Re: BusConnects Swords to City Centre Bus Corridor Scheme
Swords to Dublin City Centre

Swords to City Centre Core Bus Corridor Scheme Submission (Ref. No. 317121)

Brendan Collins

Programme Title BUSCONNECTS DUBLIN CORE BUS CORRIDORS INFRASTRUCTURE WORKS			
Drawing Title SWORDS TO CITY CENTRE CORE BUS CORRIDOR SCHEME TRAFFIC SIGNS AND ROAD MARKINGS			
Drawing File Name	Sheet Number	Status	Rev
BCIDB-JAC-TSM_GA-0002_XX_00-DR-CR-0013	13 of 37	A	M01

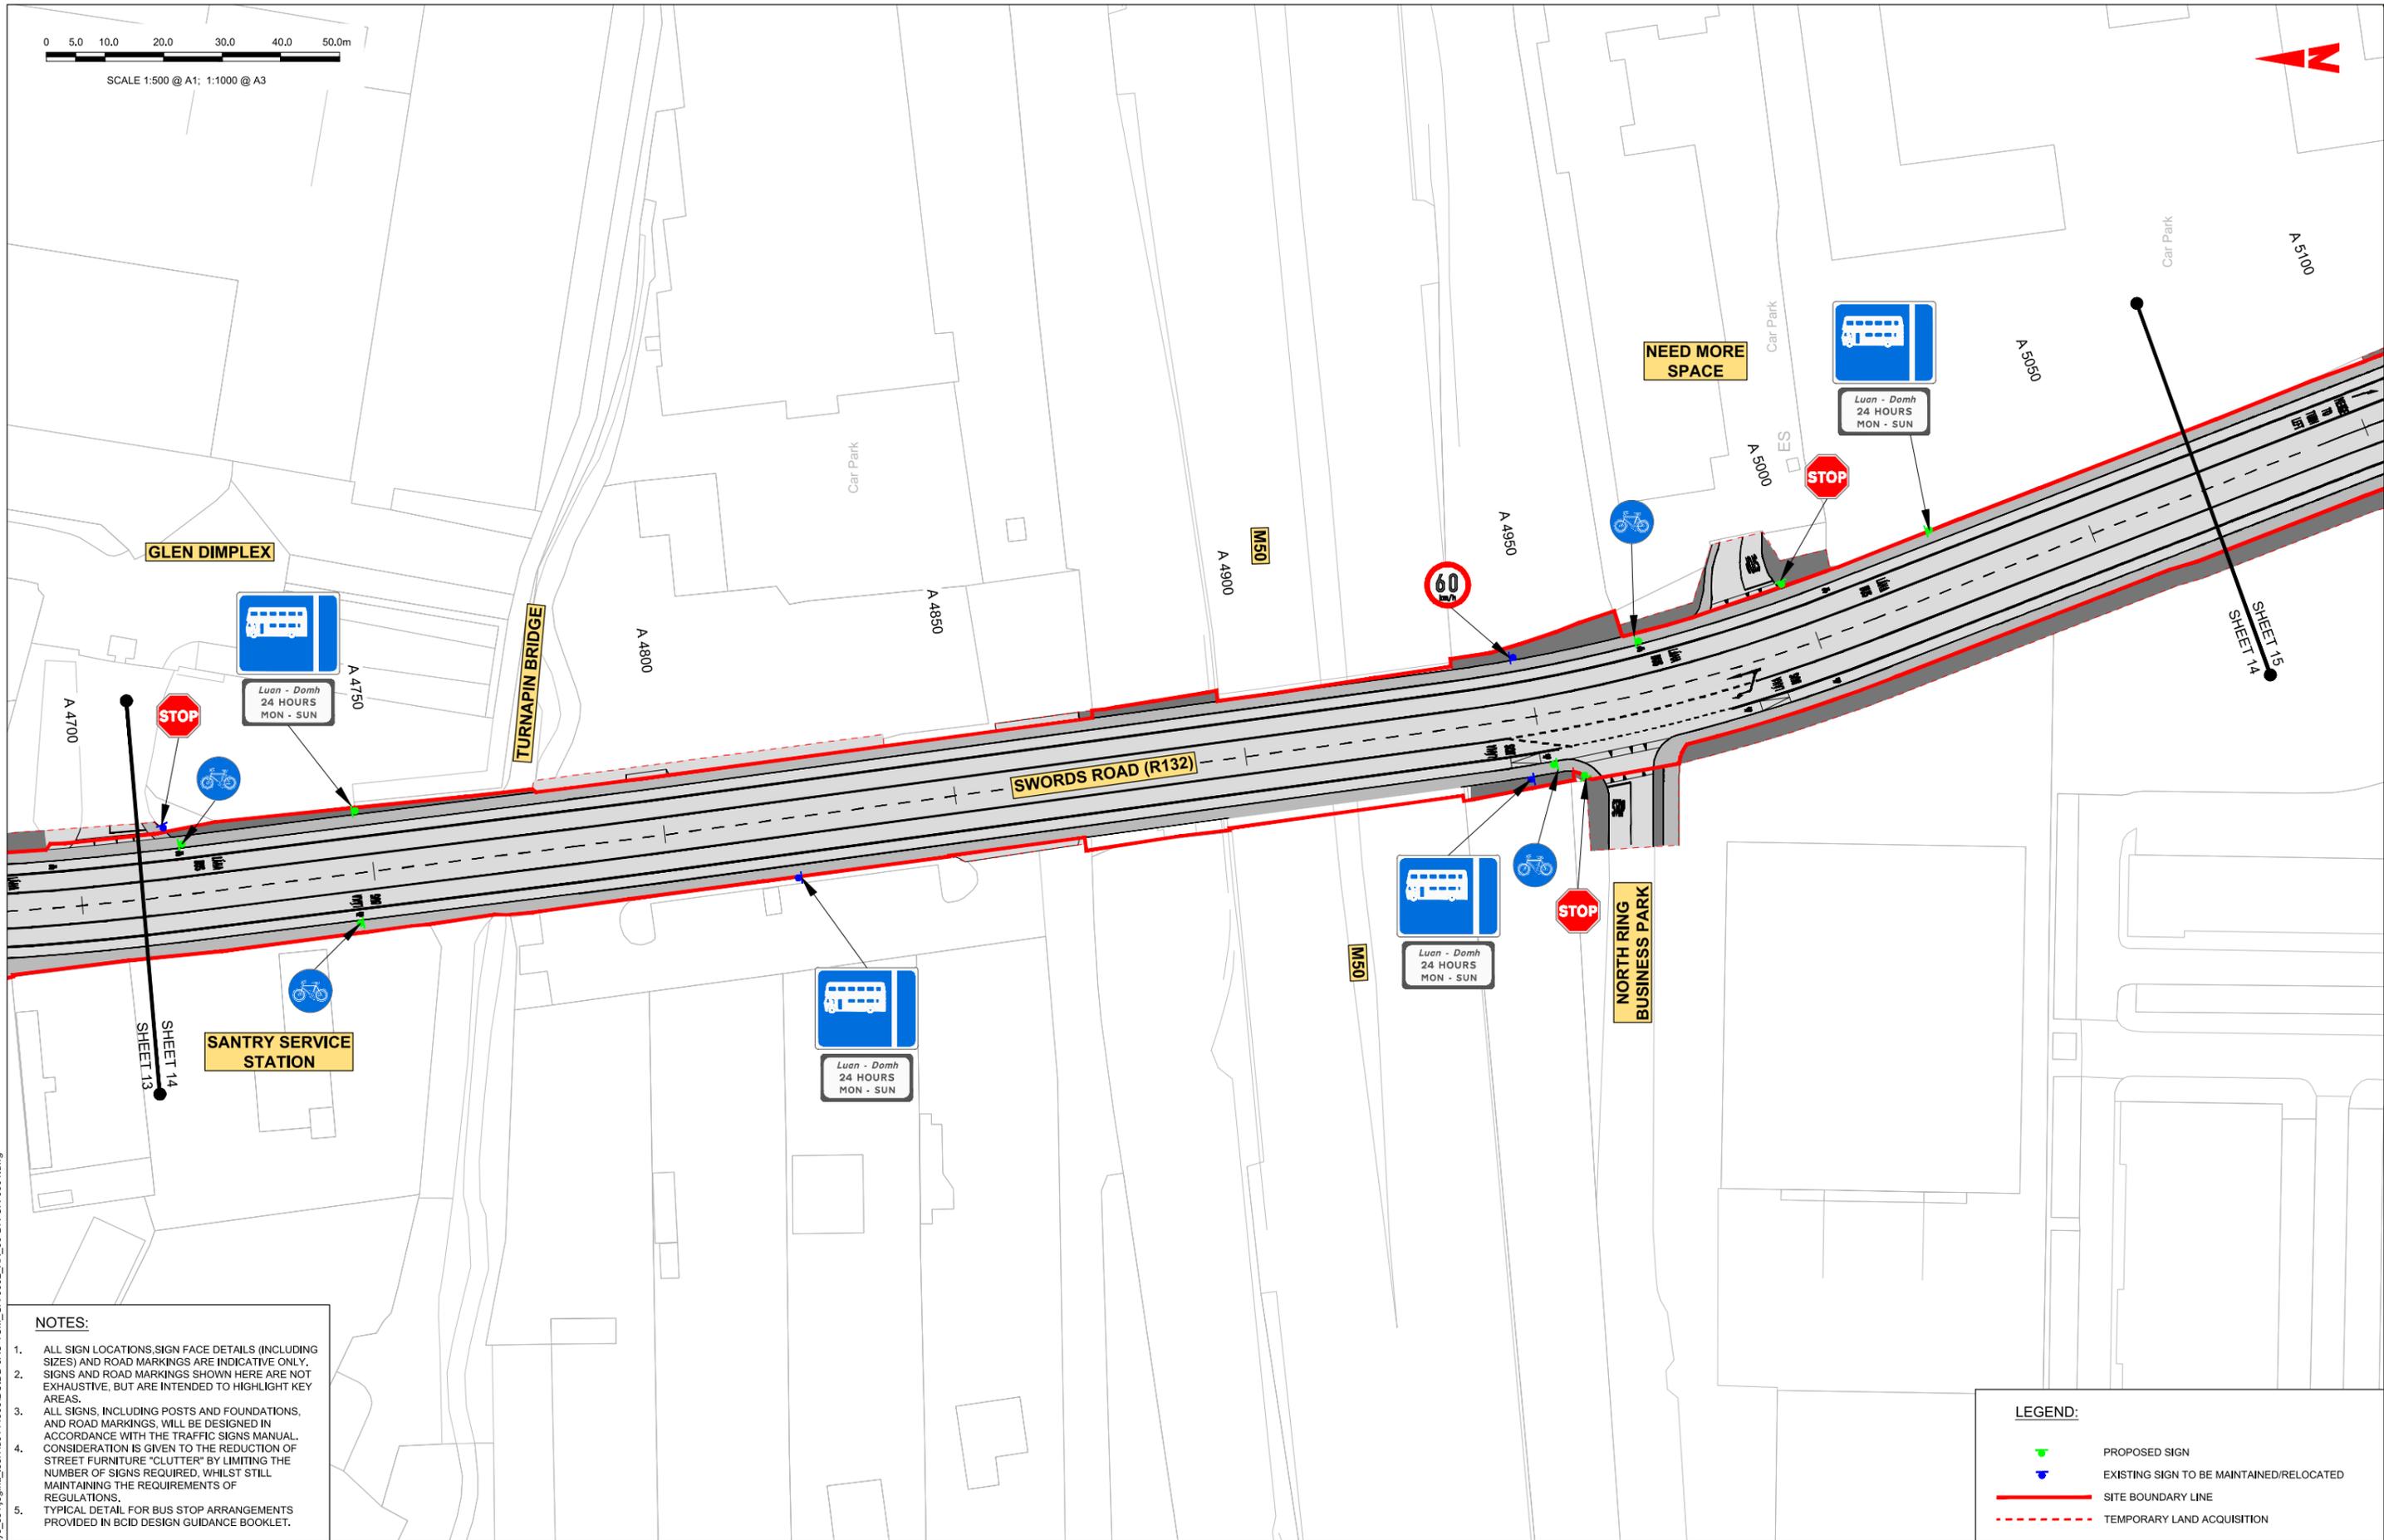
Further to the replacement of hardstanding with the grass verge area, the proposed works will significantly curtail the ability of the subject site to facilitate access/exit to multiple vehicles at once through the restriction of the entrance/exit points to single lane width. The scheme drawing Sheet 13 of 37 also shows a proposed entry treatment ramp across the reduced width access, with the public footpath crossing point stepped inwards onto the flat zone area of the entry treatment ramp (so that it would be partially behind the site boundary line), and the stopline/stop road marking text has been located to the rear of the inner toe of the entry treatment ramp.

This is significant in that not only can the revised site not facilitate the entrance/exit of multiple vehicle movements, but the works could also result in vehicular queuing both upon the Swords Road and within the subject site, principally in the context of Heavy Goods Vehicles (HGVs). This will present direct impacts to both traffic flow along the Swords Road whilst compromising vehicular movement within Collinstown Business Park and impacting upon the movement of people and goods around the park. It is also considered prudent to note that the works to the entrance/exit arrangement will also affect the accessibility of our client's personal residential property which is accessed from the same vehicular gate off the Swords Road thus compromising the residential amenity of this property.

In relation to proposed works on site, it is our position that the existing entrance/exit arrangement should be maintained in situ insofar as the subject site does not prejudice the delivery of the primary objective of the Swords to City Centre Core Bus Corridor Scheme.

In this regard, and in the interest of safeguarding the long-standing entrance/exit arrangement to the subject site, our client would herein confirm their willingness to engage with the NTA in relation to accommodating pedestrian/cycle infrastructure and facilitating the provision of a signalised junction upon lands within their control.
